Re: Planning Application M/47/14/PL
Grasmere
Ancton Lane
Bognor Regis
West Sussex
PO22 6NL

I write with regard to the above planning application. The proposed new development is fundamentally the same building proposed in a previous application, M/8/14, and we object to the proposed replacement dwelling for the following reasons.

| DRAWING TITLE:<br><b>EX &amp; PRO STREET<br/>SCENE</b> | DRG NO:<br><b>PL05</b> |

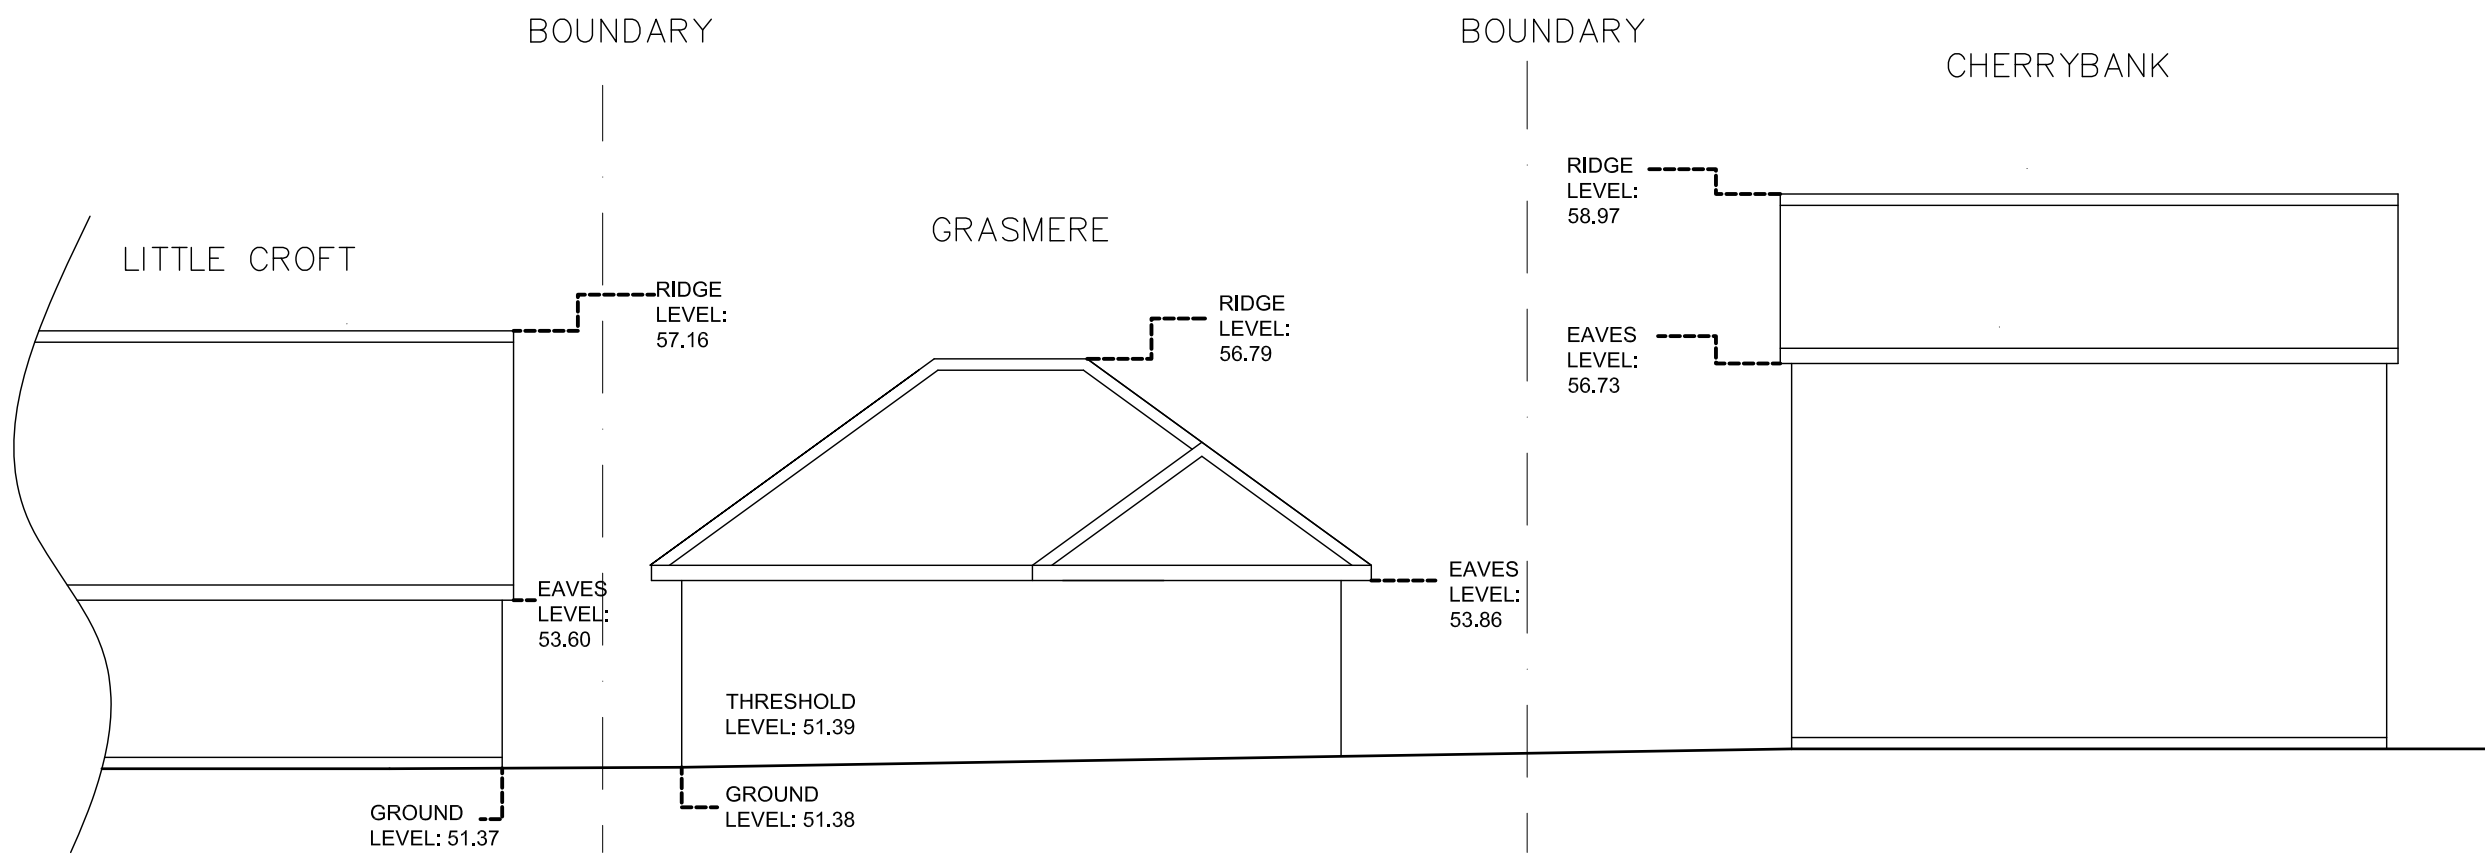
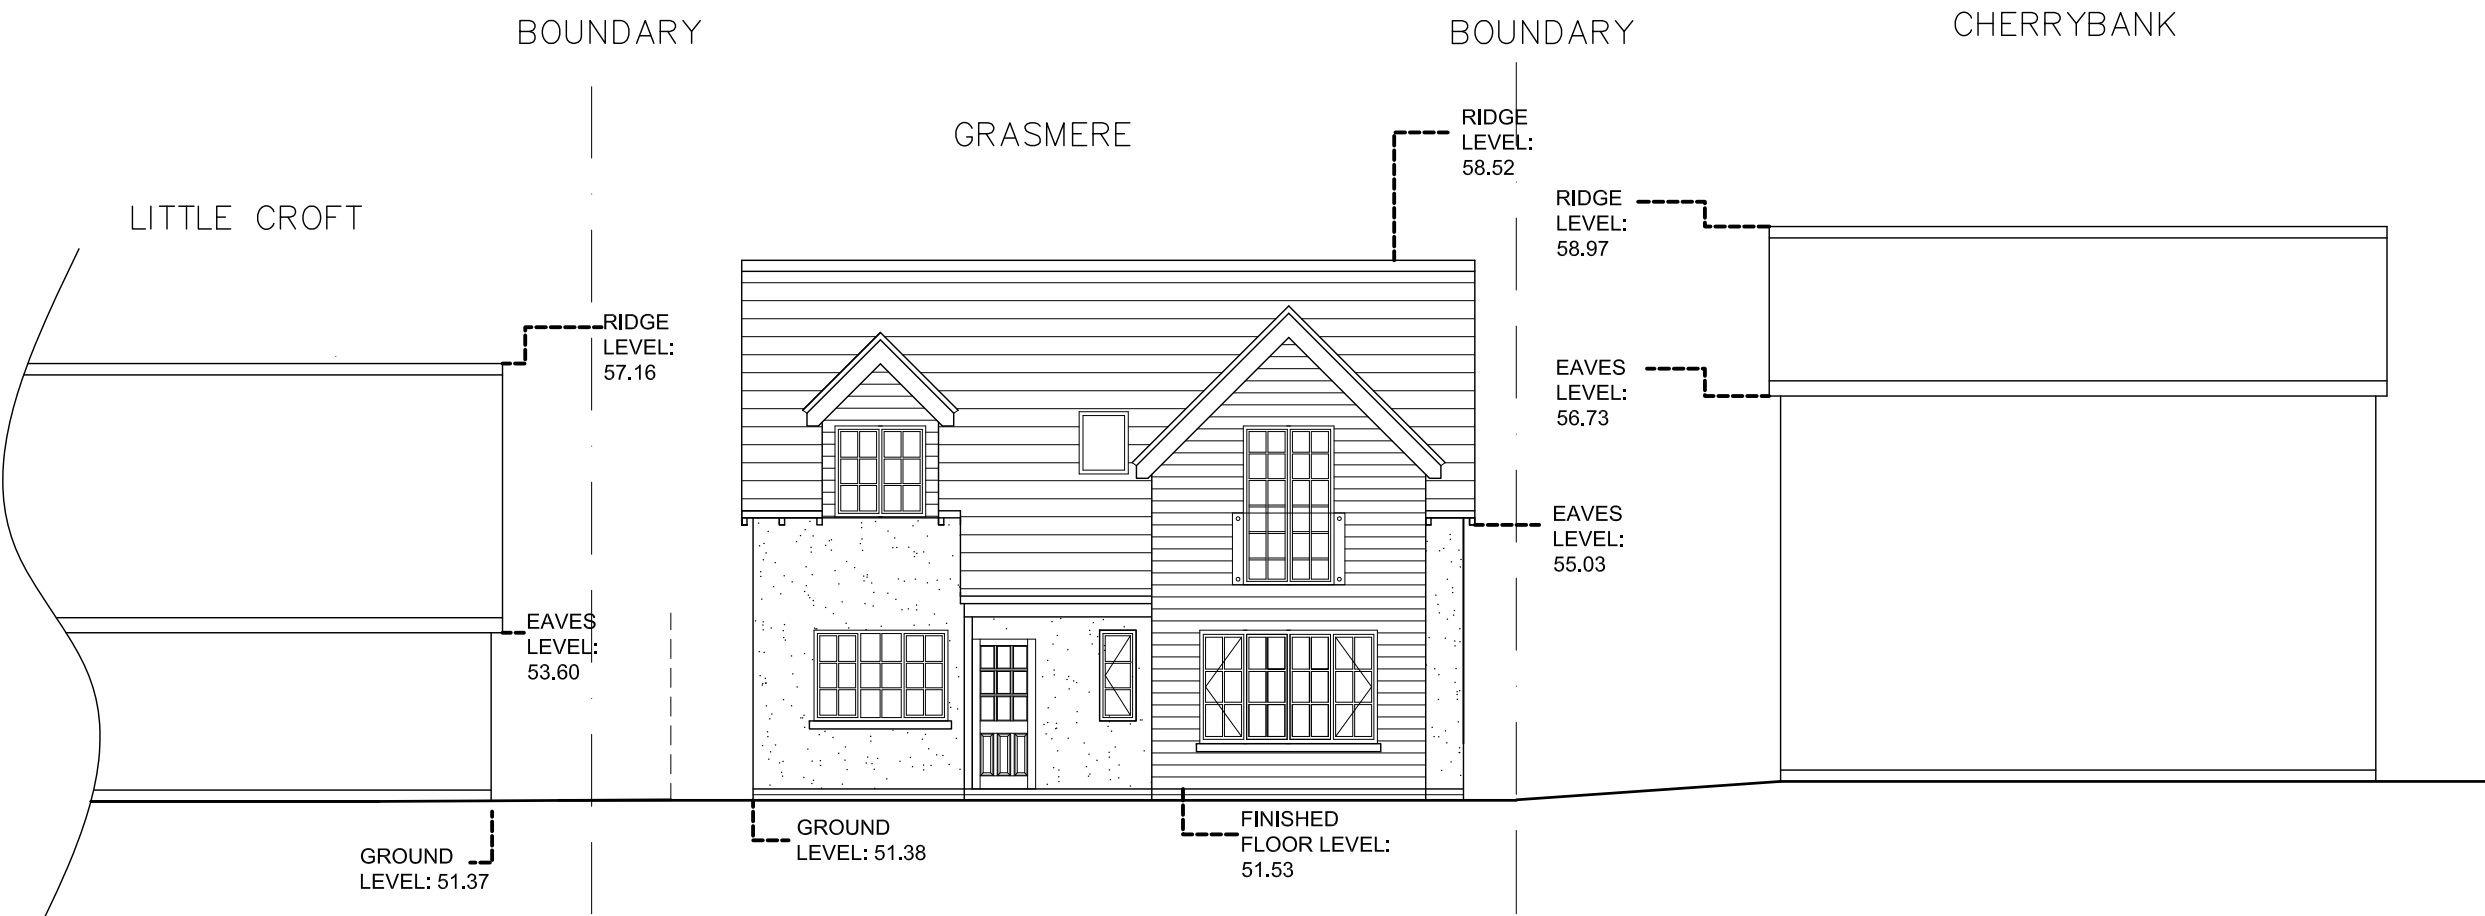
1. The new dwelling is an over development of the site and of a scale that is not in keeping with location, neither is it in relation to all the remaining properties in the lane to the East of the proposed development which it is immediately adjacent to (Little Croft, Greenbanks, Petite Etoile and Hazelbanks). It is comparable in height and visual impact to the house to the West (Cherrybank), although owing to lack of clarity on the street scene elevations it is difficult to ascertain the precise height. Cherrybank is set further back than the bungalow it replaced and is on a much larger plot, with its building line matching the properties to the West of it, so as not to be overbearing on the street scene and the single storey properties to the East. The proposed new dwelling would dramatically alter the street scene. The attempt to alleviate concerns with regard to adjacent properties by placing the building further forward in the plot increases the overbearing impact on the street scene without giving sufficient relief for surrounding properties. With regard to the ridge height it seems logical that the proposed dwelling should be set back, not forward, in the plot to be in keeping with scale, street scene and previous developments.

PROPOSED
ELEVATIONS

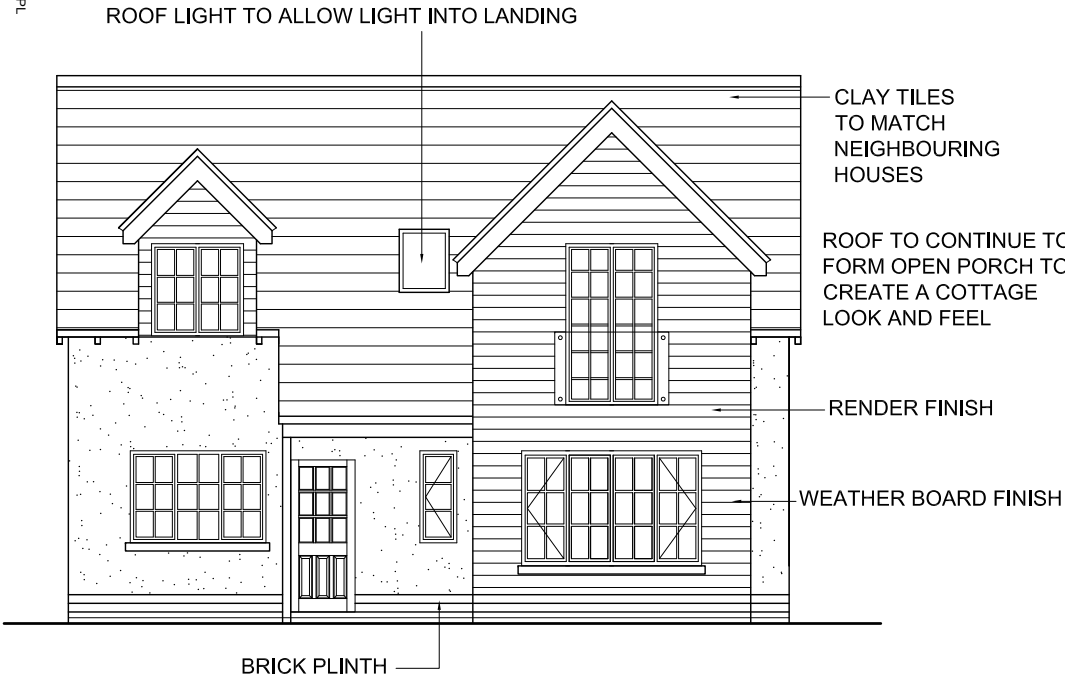
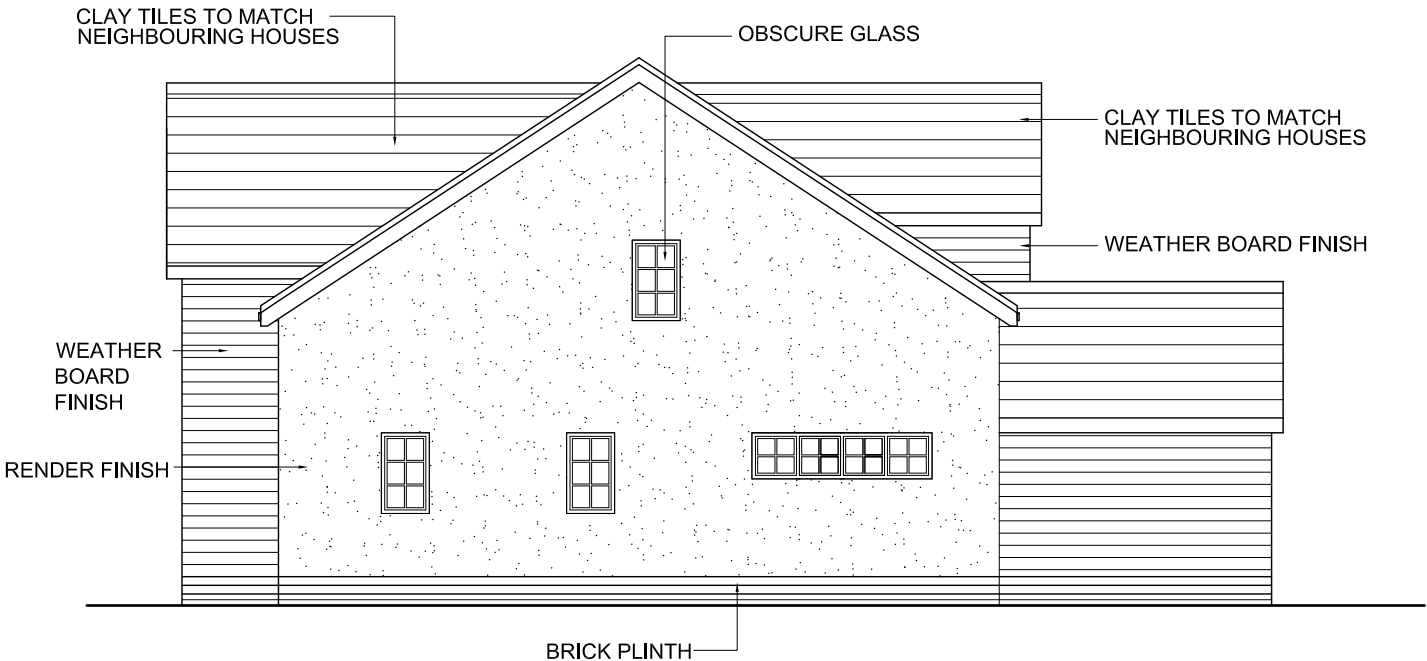
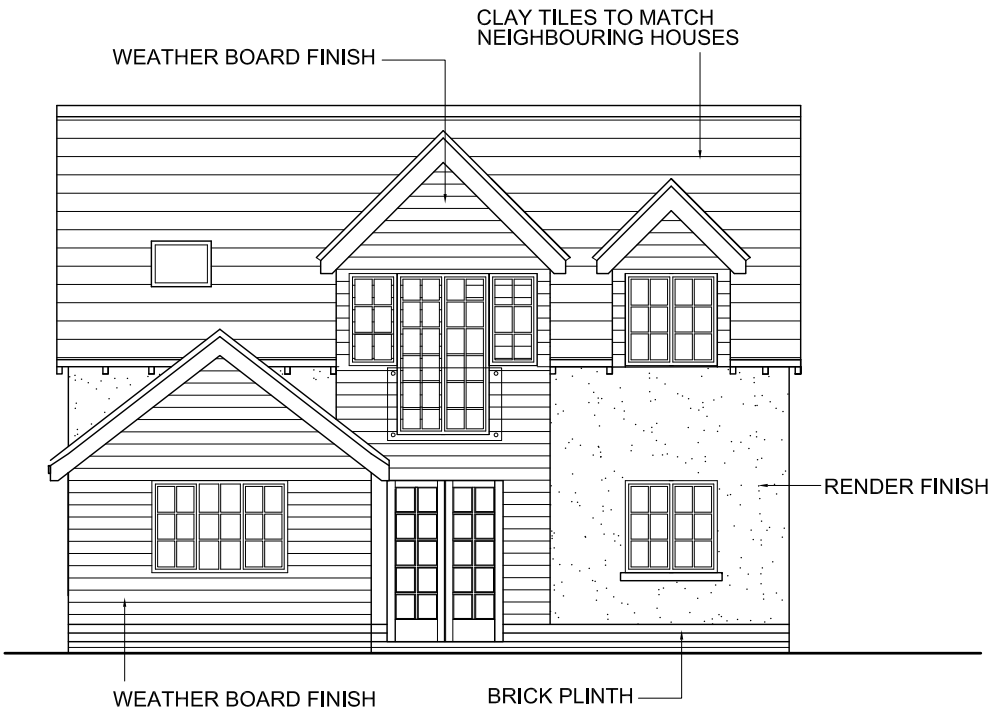
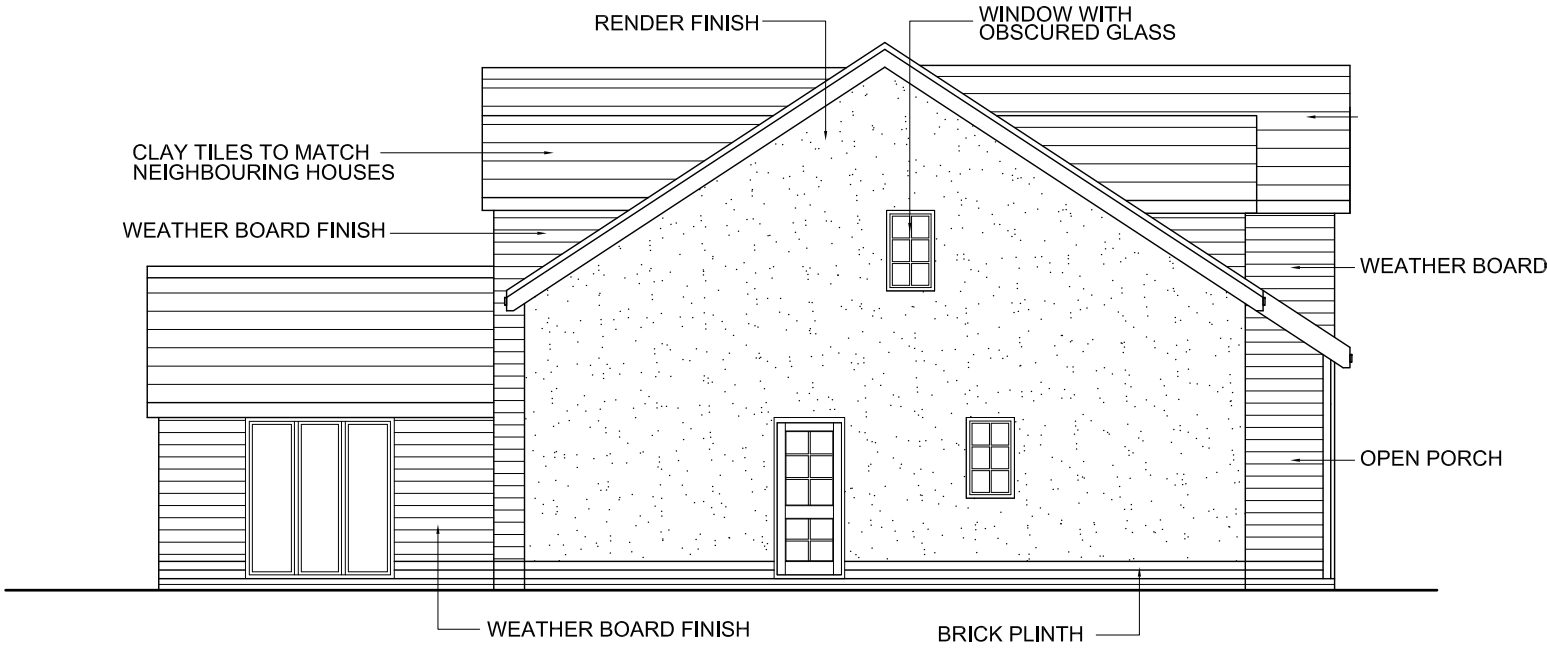
3. The new dwelling will seriously affect our privacy and the peaceful enjoyment of almost all our rear garden and terrace area as the rear 2nd storey windows of the proposed building will directly overlook us. The extent of the upper rear windows in

the proposed building will compromise the privacy of the properties around it and its own. In addition to this it should be noted that the right to privacy, a family life and to peaceful enjoyment of ones home are well established rights in law. Please see the attached photograph demonstrating the current impact Grasmere has on privacy. Grasmere is the tiled roof, central, in the photograph (already received, see M/8/14).
